PHILIP HEARD IP NUMBER [REDACTED]: FOSSE GREEN DEADLINE 3A SUMMARY

PHILIP HEARD IP NUMBER F86A1944A: FOSSE GREEN DEADLINE 3A COMMENTS

This submission covers the Applicant's comments in response to ExQ1 (REP2-029) and Deadline 1 Submissions (REP2-030), plus a final conclusion. Key takeaways include the Applicant's use of high load factors, underestimation of Greenhouse Gas (GHG) emissions, excessive overplanting of solar PV panels and failure to recognise permanent sealing of land.

DOCUMENT REFERENCE
EN010154/APP/6.2

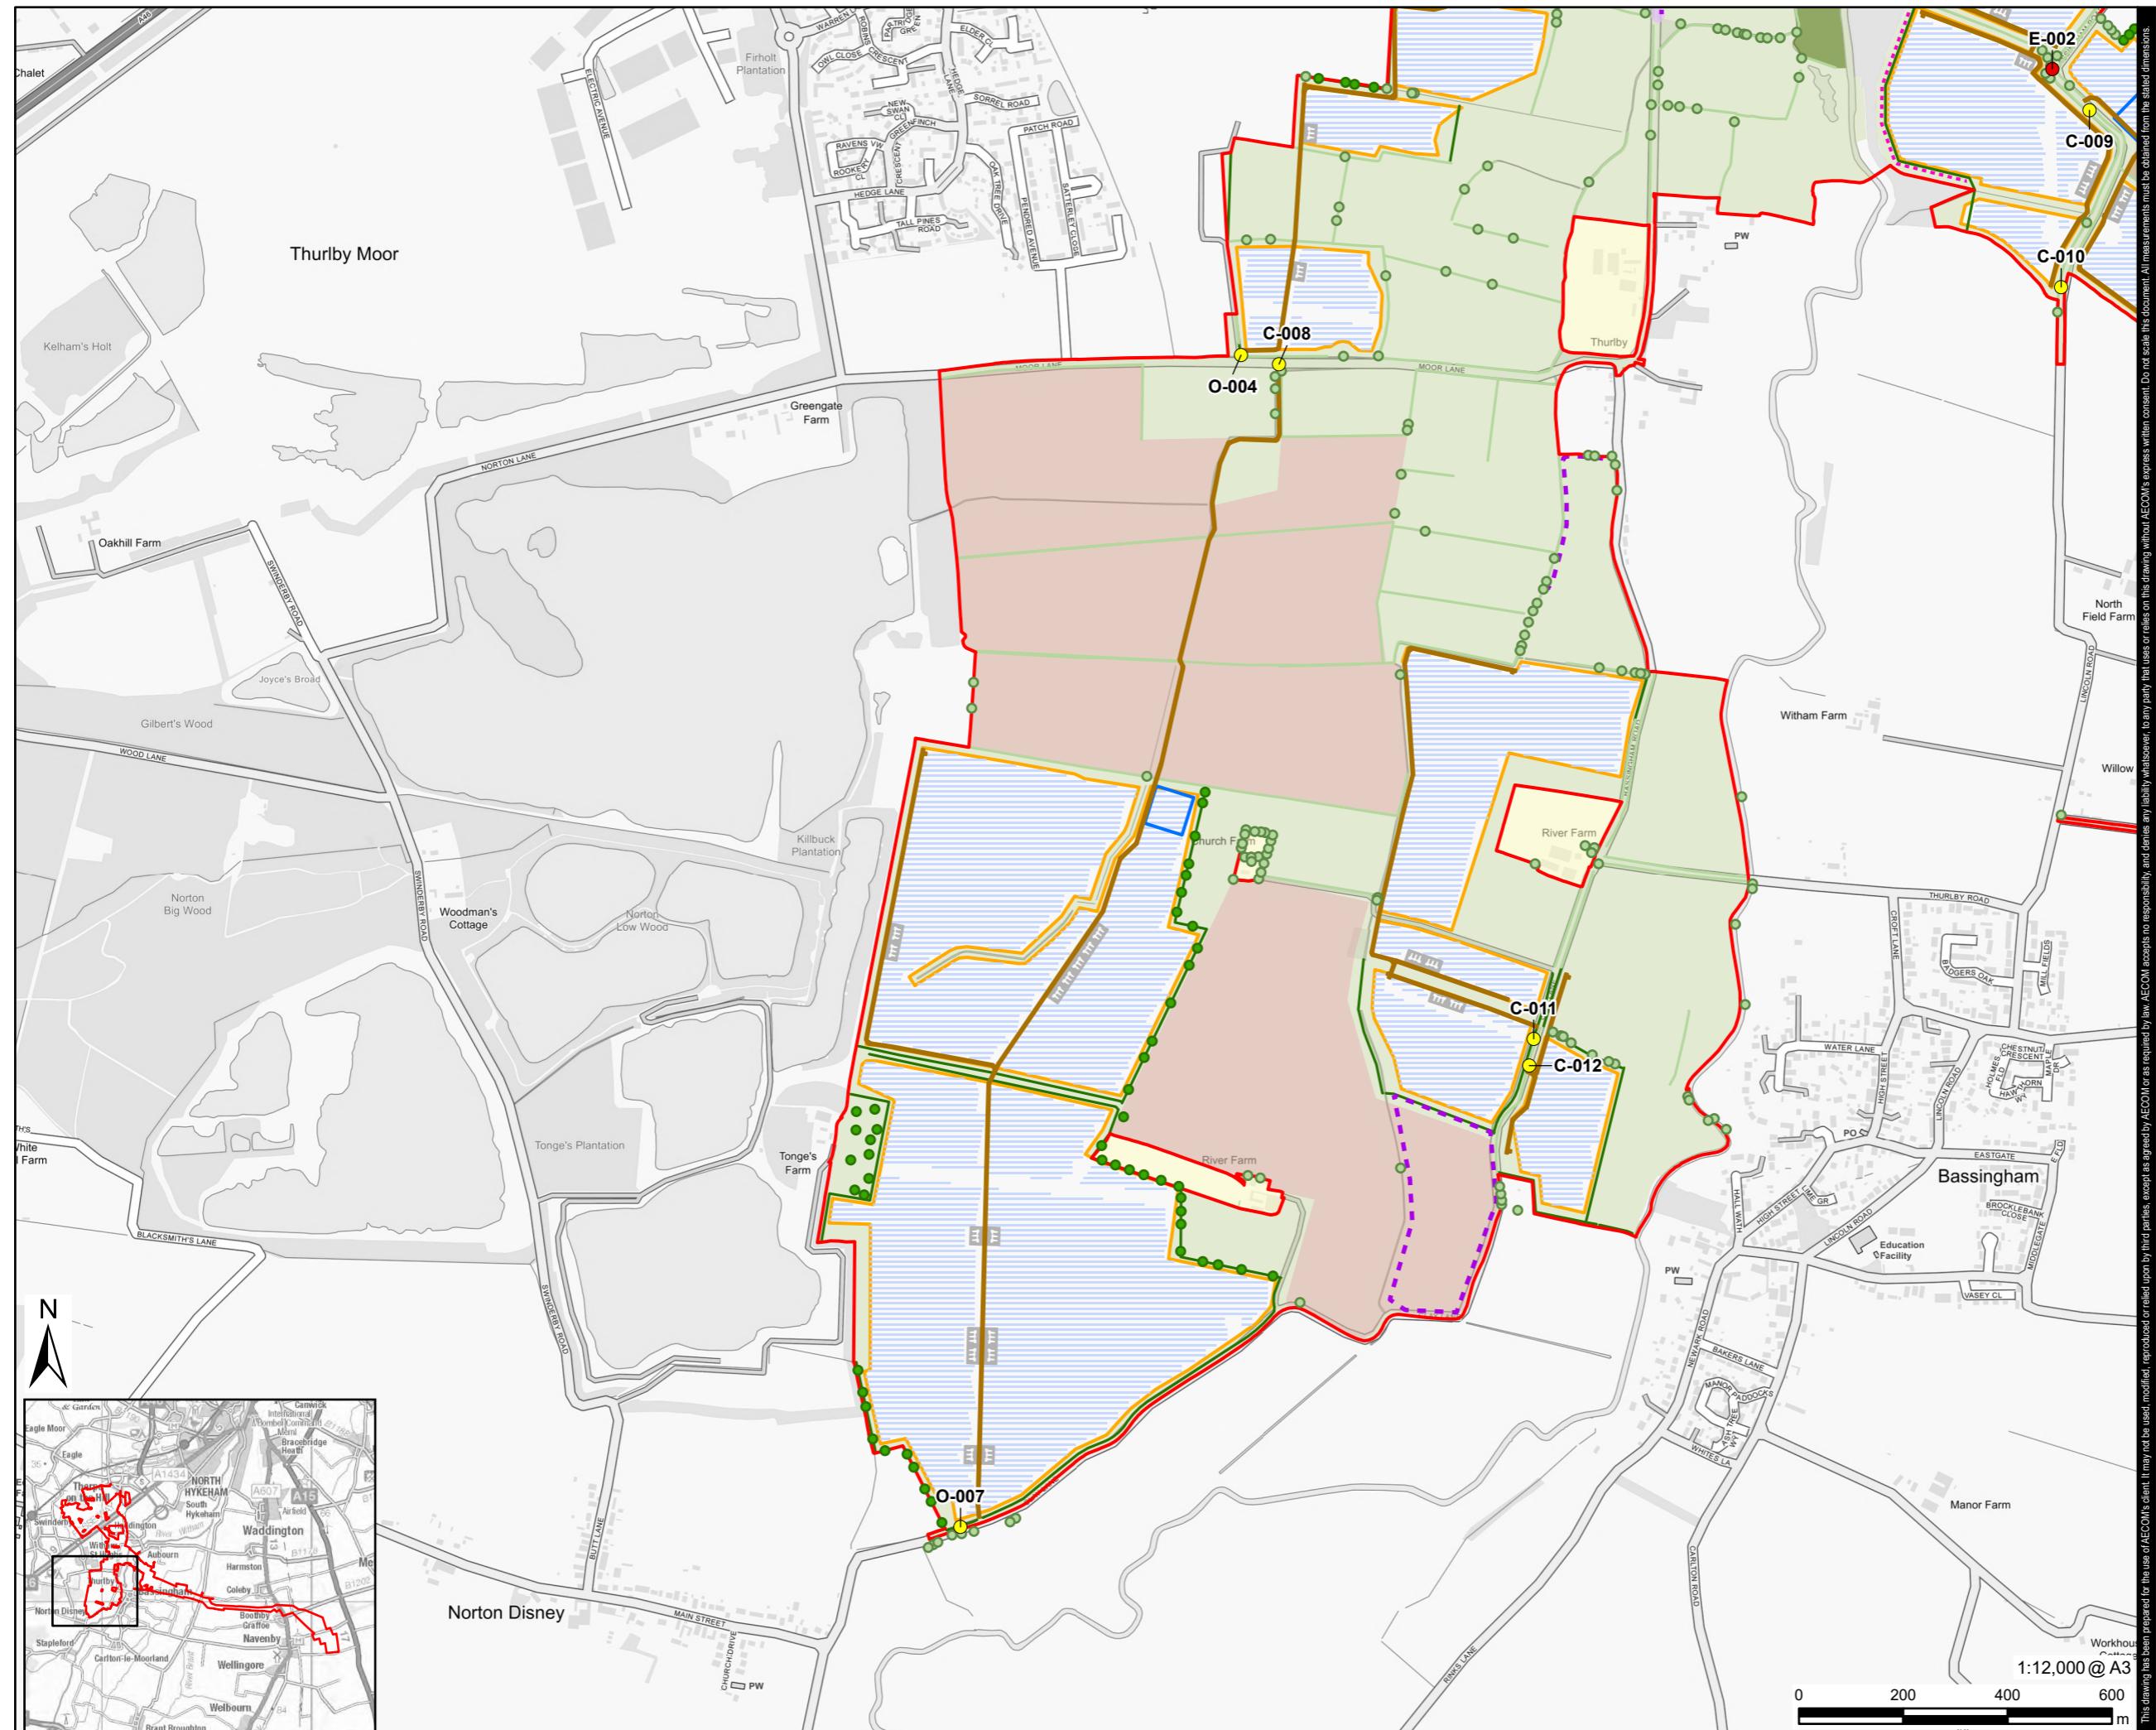
Regarding the overplanting ratio, the Applicant states "*adopting an overplanting ratio of 1.6 results in an overplanting ratio of 1.02 at year 30 when accounting for module degradation and Nominal Operating Cell Temperature (NOCT) conditions.*" Yet REP2-033, Table 5.2 for NOCT conditions commences at Year 1 with an overplanting ratio of 1.17 NOT 1.6. As REP2-033, Paragraph 5.3.1 states that NOCT better accounts for UK conditions, an overplanting ratio no greater than 1.2 can be justified. This results

in a reduction, for example of the fixed south facing option, of 139,250 panels to 426,750.
